A585 Windy Harbour to Skippool Improvement Scheme

TR010035

7.11 Environmental Statement Changes and Corrections Document

July 2019

Status	DEADLINE 2 SUBMISSION	Revision	1
Scale	1:2500 A3	Date	MAY 2019
Drawn By	J.NORMAN	Checked By	K.BURROWS
Approved By	N.HENDERSON		
PINS No.	TR010035	FIGURE	11.4
Drawing number	HE548643-ARC-EGN-SZ_ZZ_000-DR-LE-30

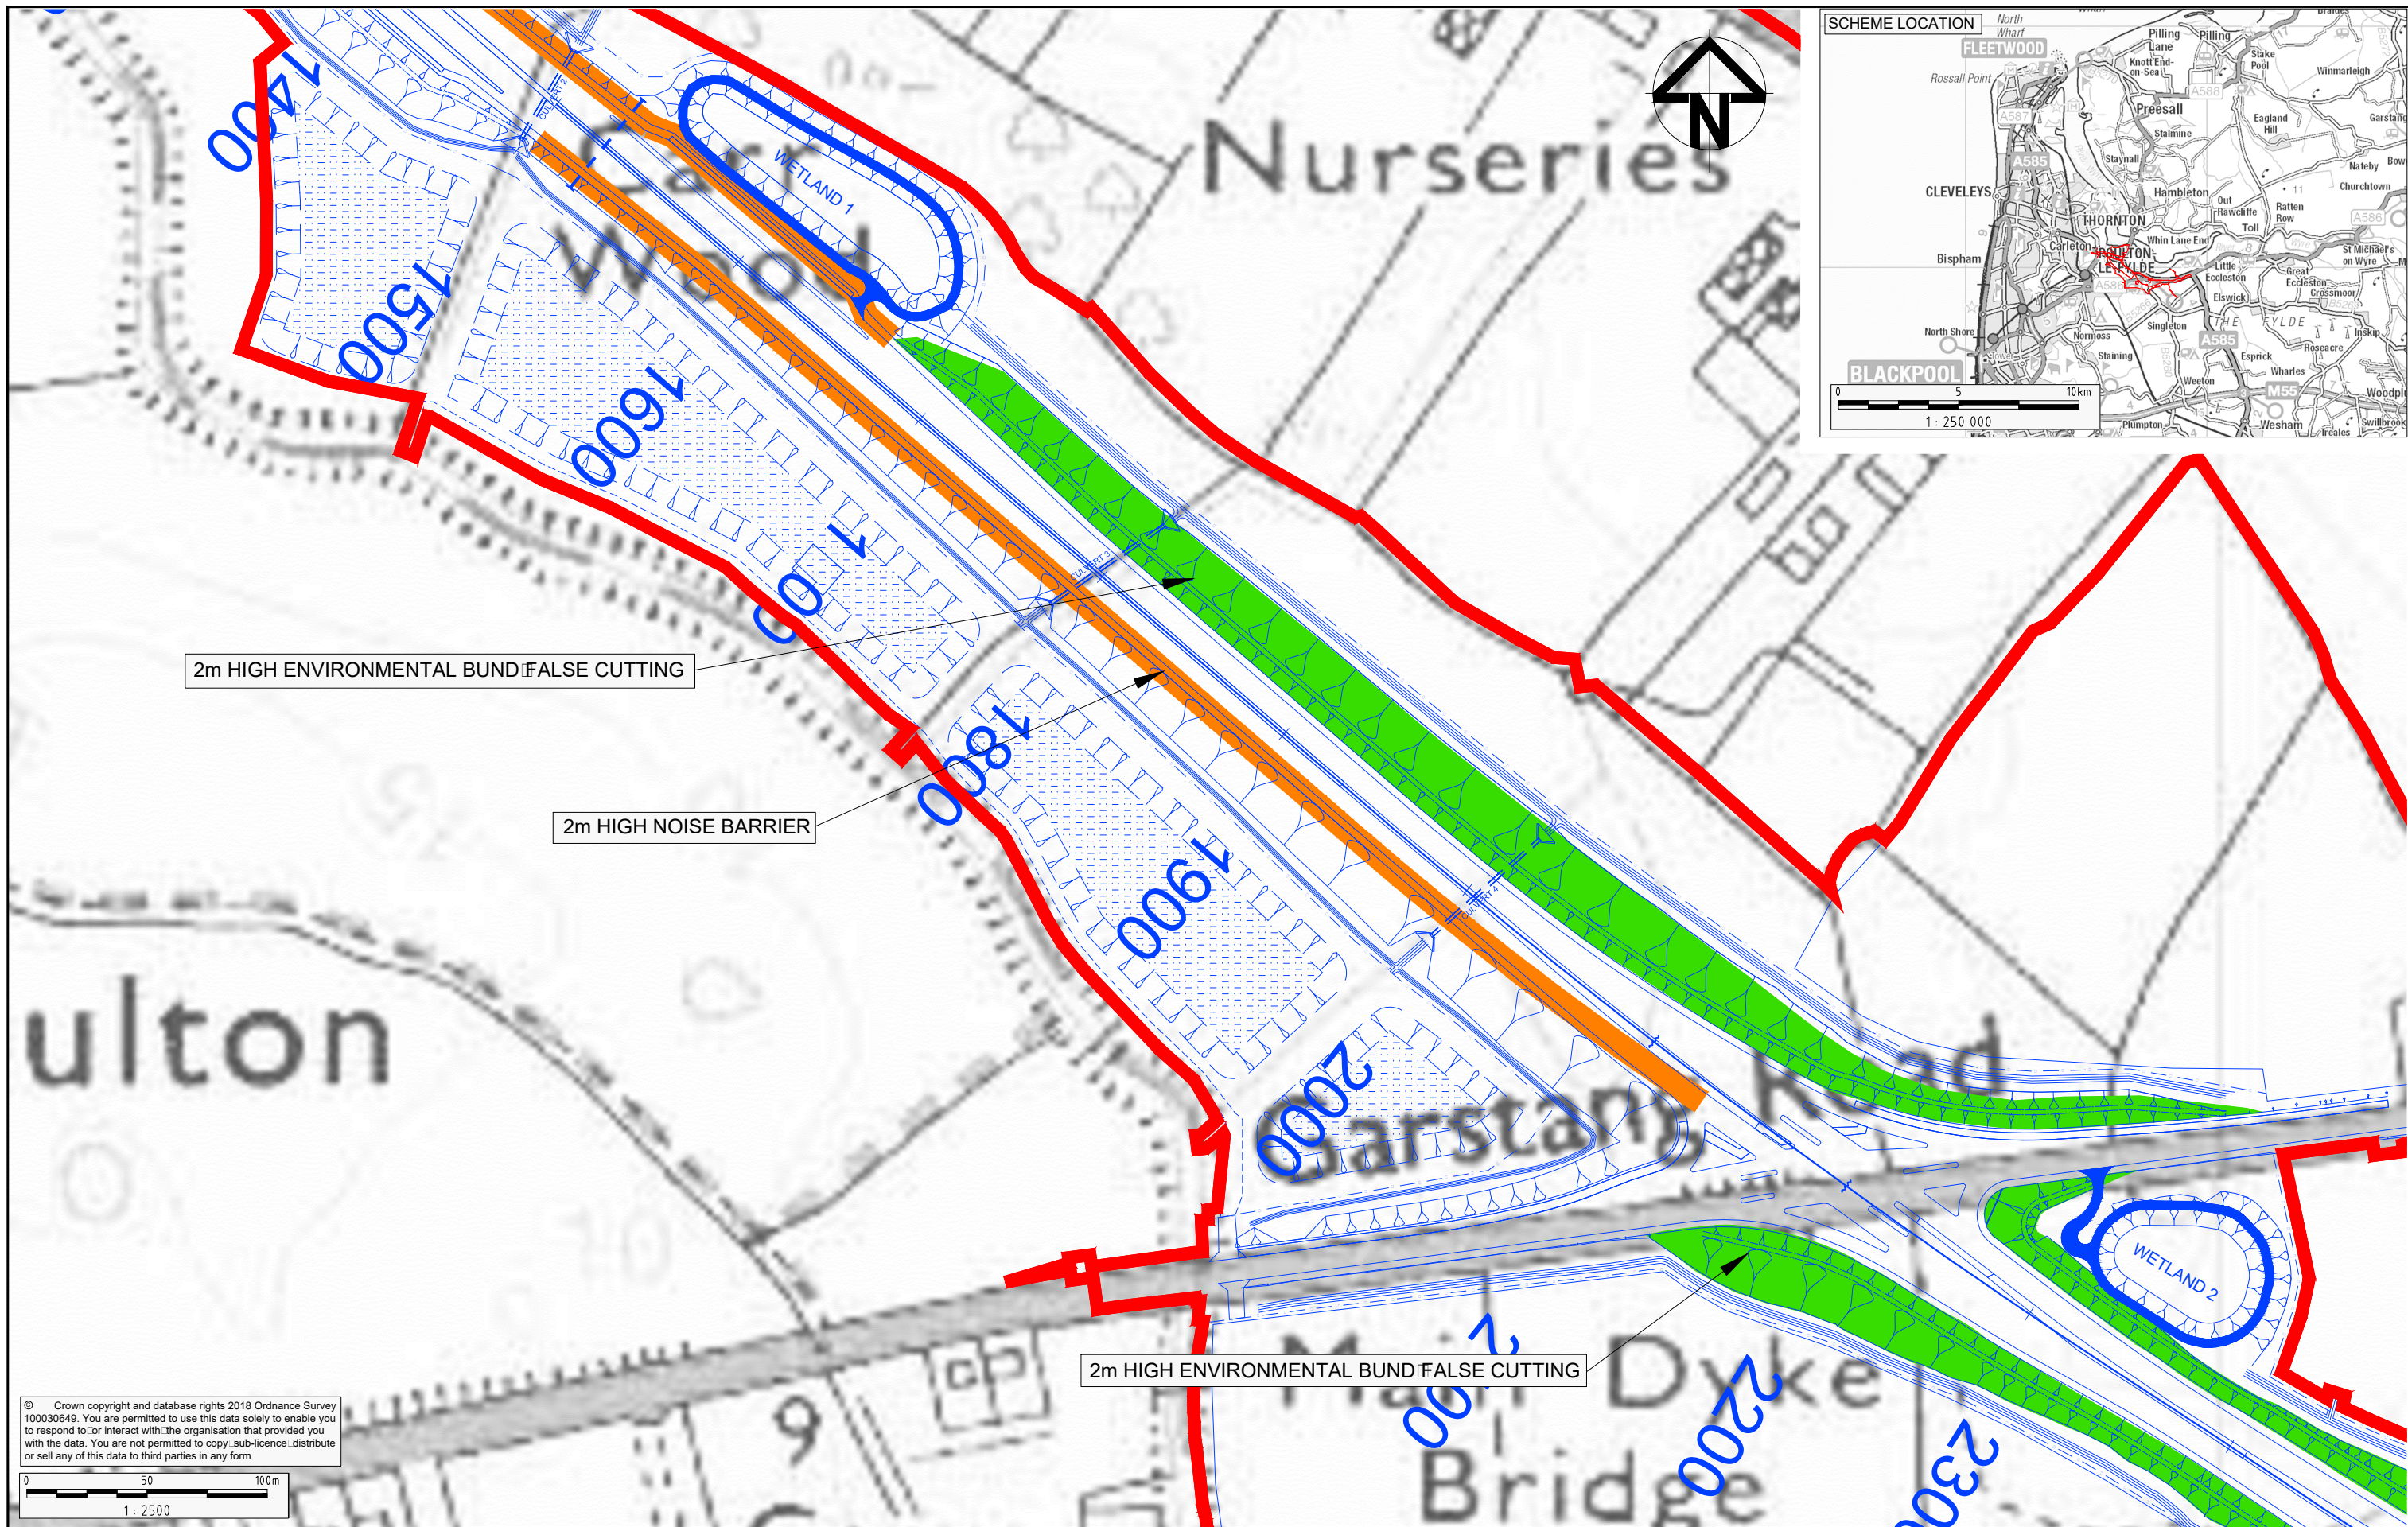
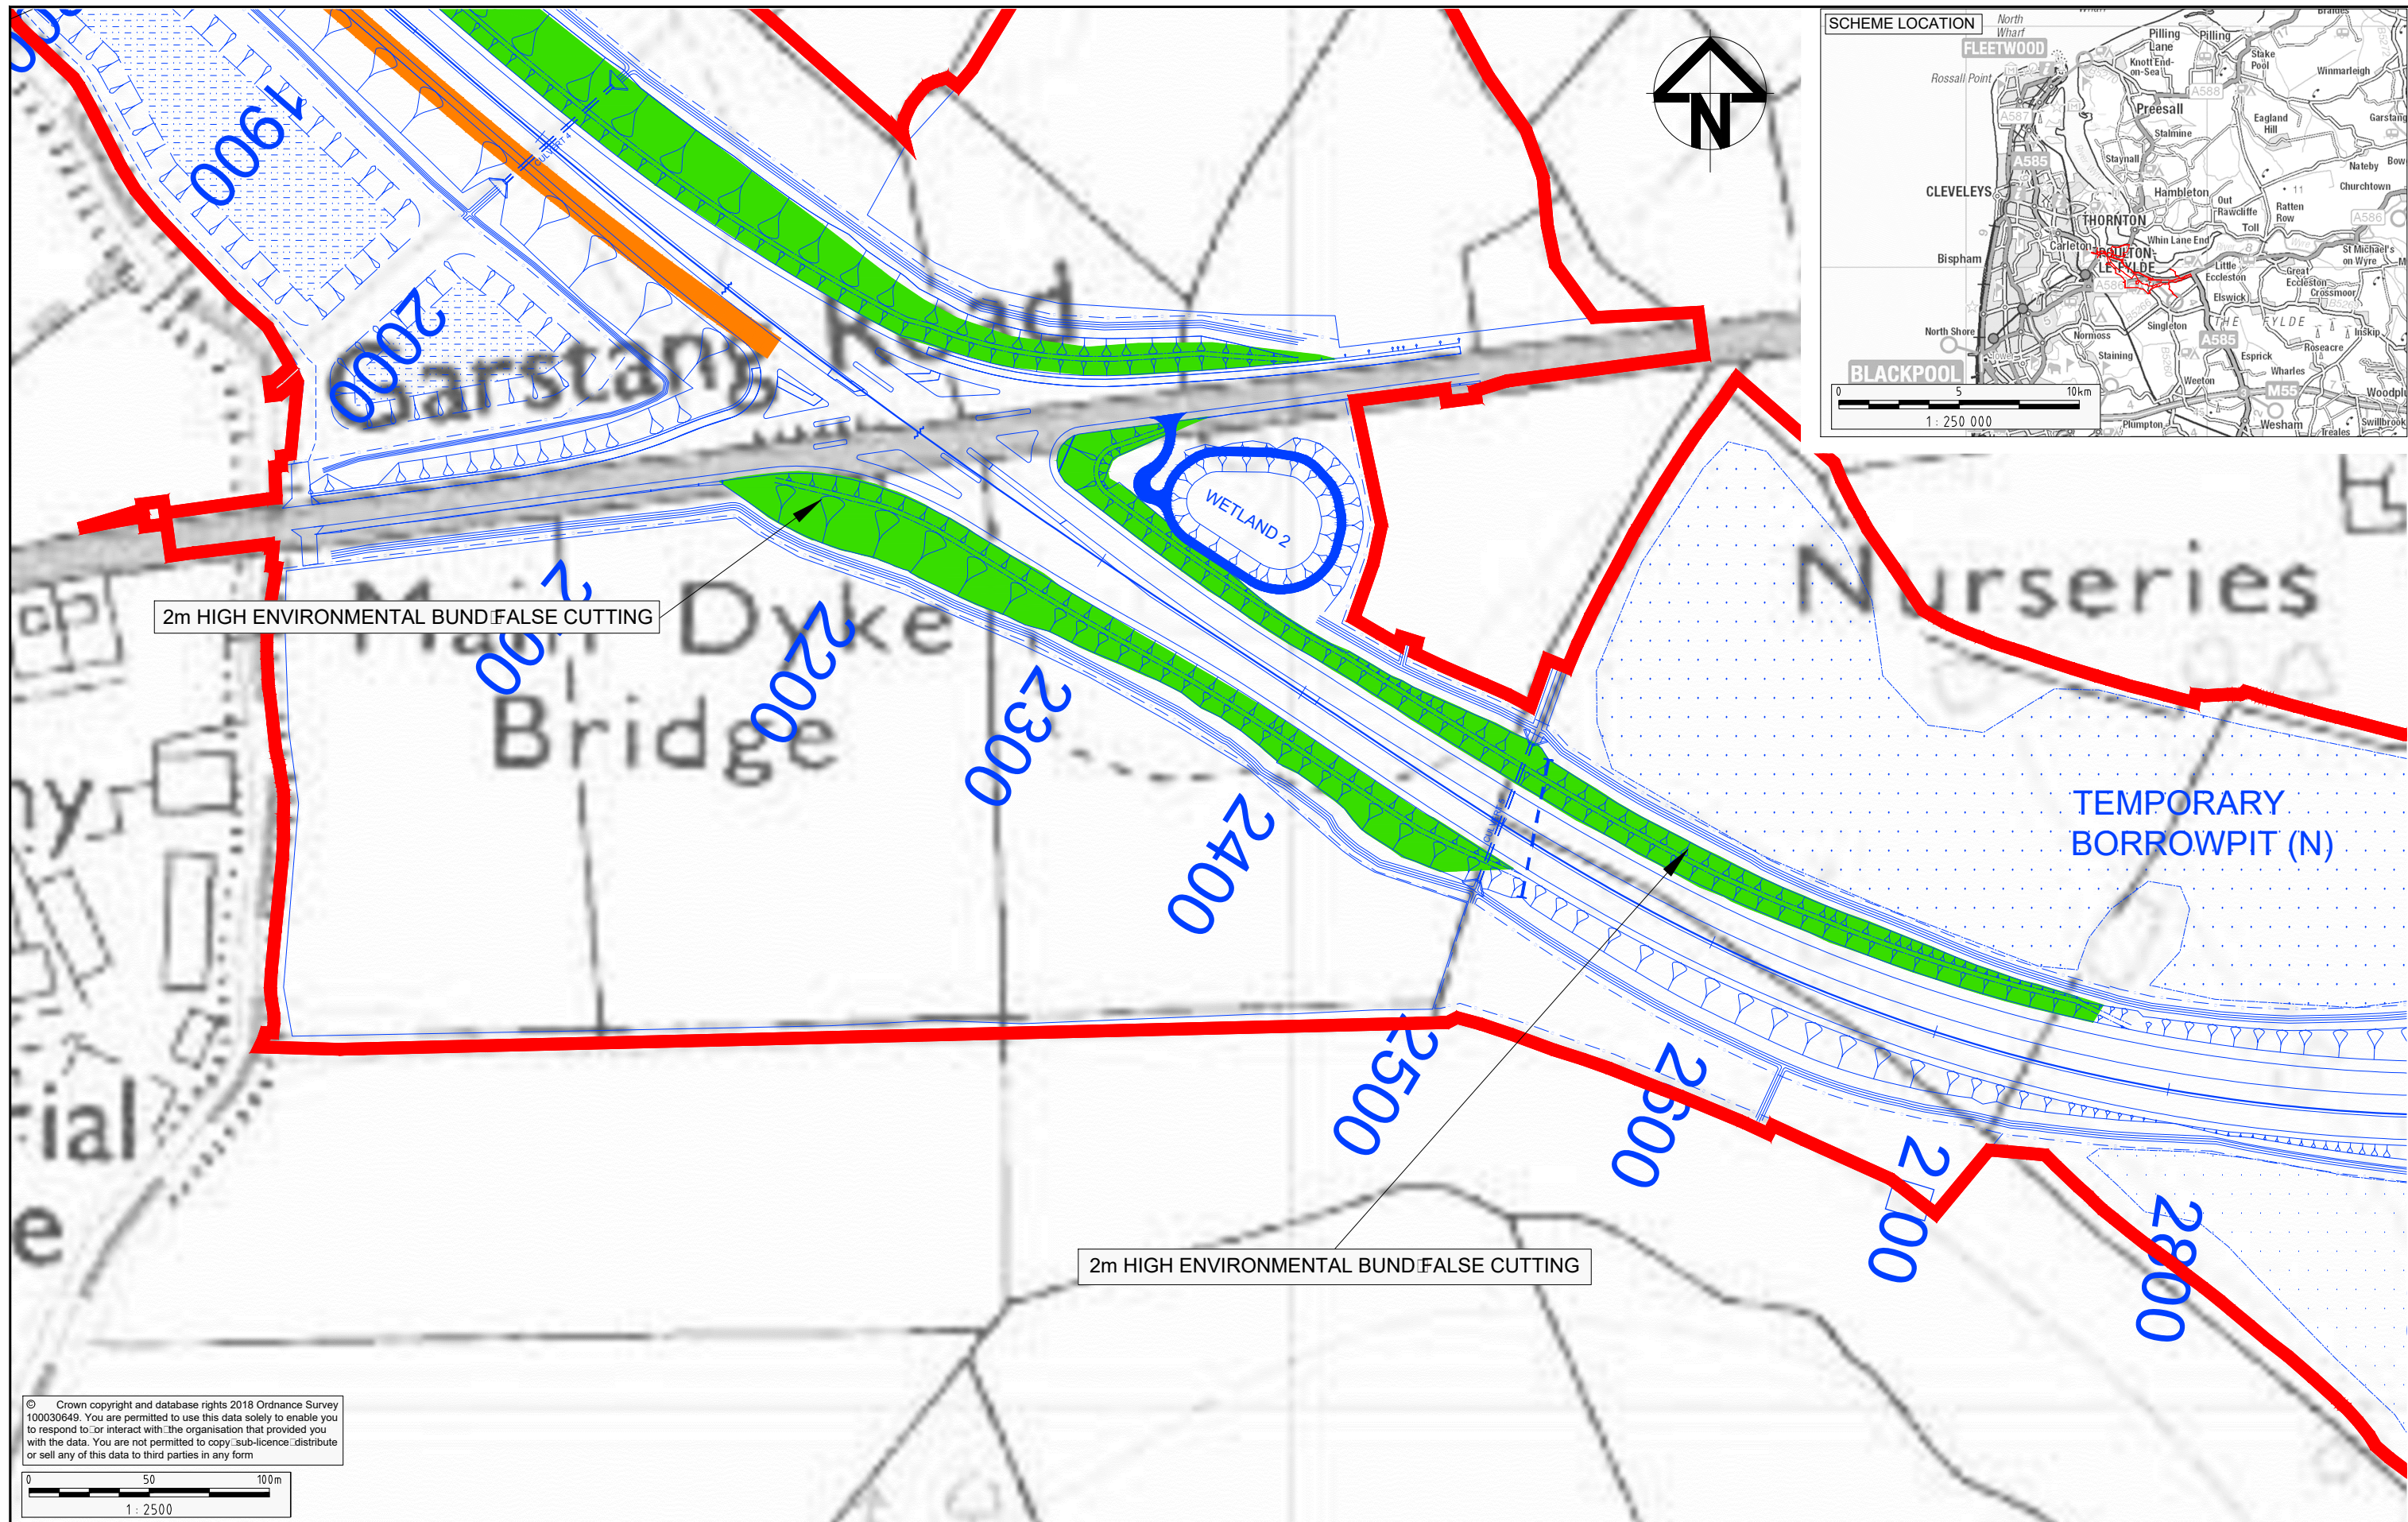
Document Reference Number	Document Name	Amendment Required	Reason
			TR010035/APP/7.10).
6.11	ES Chapter 11: Noise and Vibration	Update to Figure 11.4: Noise and Vibration – Noise Mitigation within the Study Area presented at Appendix D to show heights and locations of earth mounds and acoustic fencing at a larger scale.	Requested by the Inspector within the first round of written questions (document reference TR010035/APP/7.10).
